Section 106 Town and Country Planning Act 1990
Application for Approval of Details to Satisfy an Obligation

Application to approve First Schedule Clause 4 (Public Open Space Land and Play Areas) in the Section 106 dated 28.07.22 (as amended) in relation to planning permission WA/68/20/OUT.

Land West of Tye Lane and North of Field Close & North Road Walberton

scheme: Tye Lane
Walberton, Arundel
client: Barratt Homes
drawing: LAP POS Proposal
date: July 2025

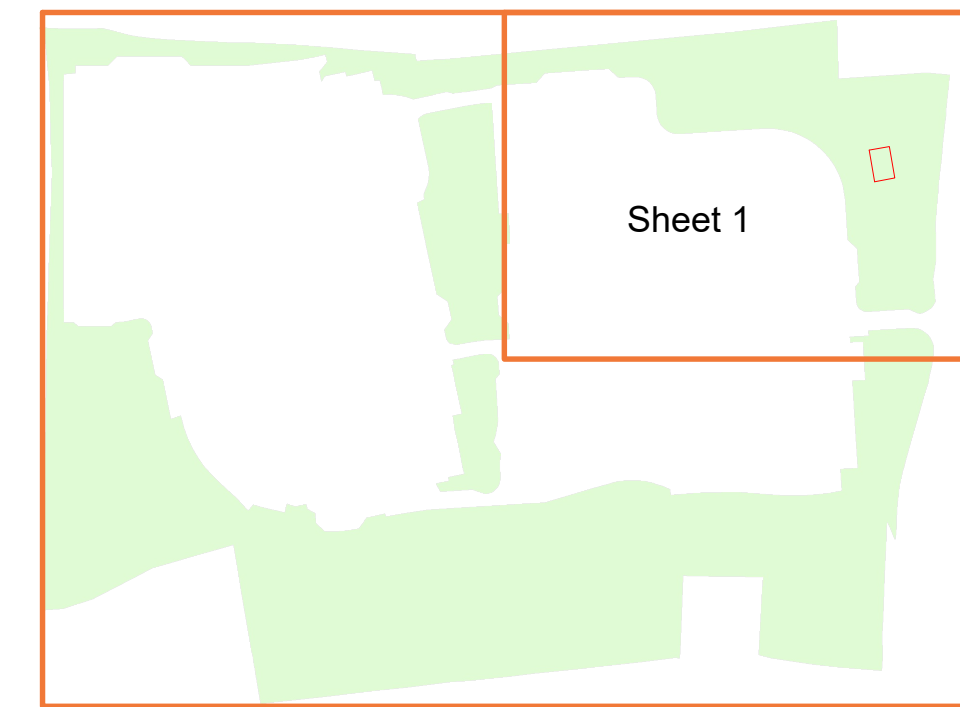
- Insufficient details have been provided as the requirements in the S106 request the detail of 3no. LAPS.

This again reinforces the requirements for 3 LAPS. Only the details of 1 no LAP and 1 no LEAP have been provided, as such the application is lacking in required details. Details of the other 2 LAPS are required to be submitted and approved in writing by the Local Authority, until such the S106 controls occupations on site.
